Clapper Short Plat

File Number SP-07-156

REVISED Conditional Preliminary Approval (Short Plat number correction)
Please see Conditional Preliminary Approval issued on May 19, 2008 for attached comments.

RE: Clapper Short Plat (SP-07-156)

<b>K.C.S.P. NO. 07-XX</b>			
Portion of the NW1/4, Sec. 20 T.18N., R.18E., W.M.			
Kittitas County, Washington			
DWN BY	DATE	JOB NO.	SHEET
T.R./G.W.	10/07	07195	1 OF 2
CHD BY	SCALE		
D. NELSON	1"=200'

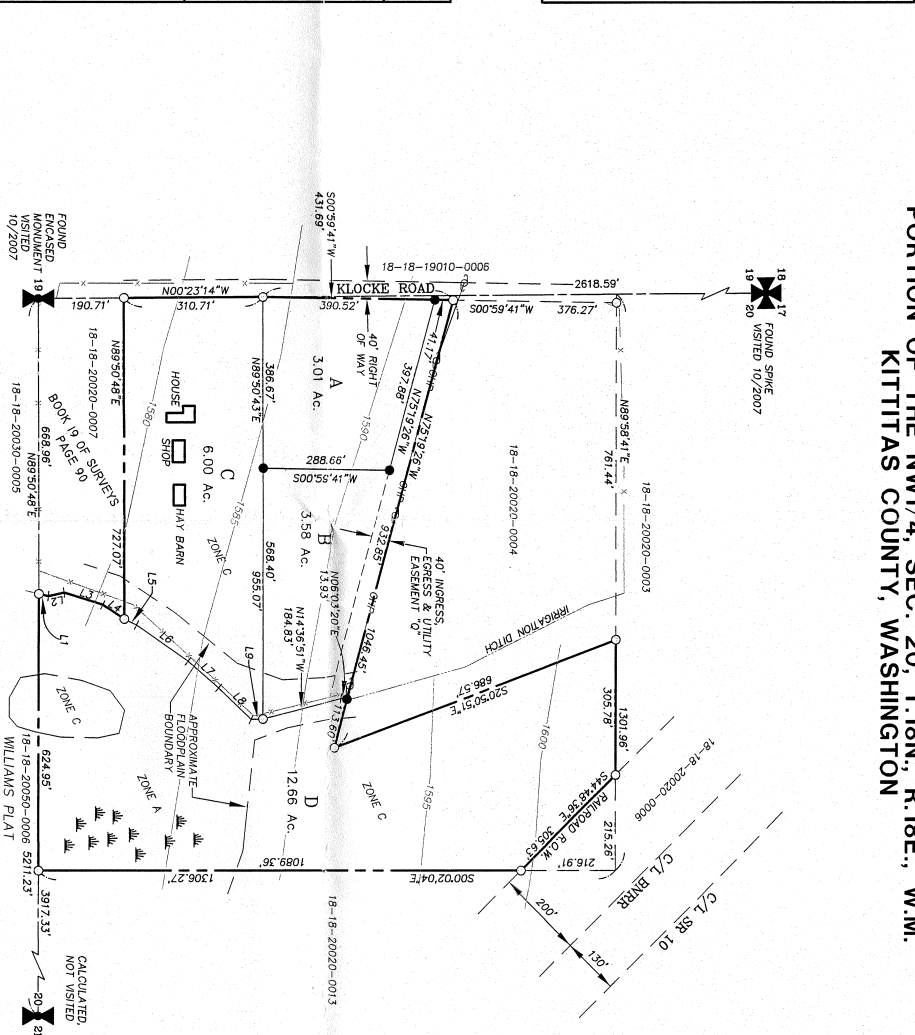
1. Both sheets of the final mylars shall reflect short plat number **SP-07-156** and an accurate legal description shall be shown on the face of the final plat.

2. Full year's taxes must be paid for 2008 on all tax parcel numbers per requirement of the Kittitas County Treasurer's Office.
3. The existing well located on Lot C shall be shown on the final mylars.

4. The PEMC wetland located on lot D shall be clearly depicted on the final mylars.
5. The following plat notes shall be recorded on the final mylar drawings:

- PEMC wetlands are shown to exist within the boundary of lot D. Any construction near this wetland may require a wetland delineation. Any land that is determined to be a wetland shall have a 20 foot buffer.

- Lots B, C and D of the Clapper Short Plat are affected by the 100 year Floodplain of Dry Creek. All future development shall comply with Kittitas County Code 17A: Critical Areas and Kittitas County Code 14.08: Flood Damage Prevention.
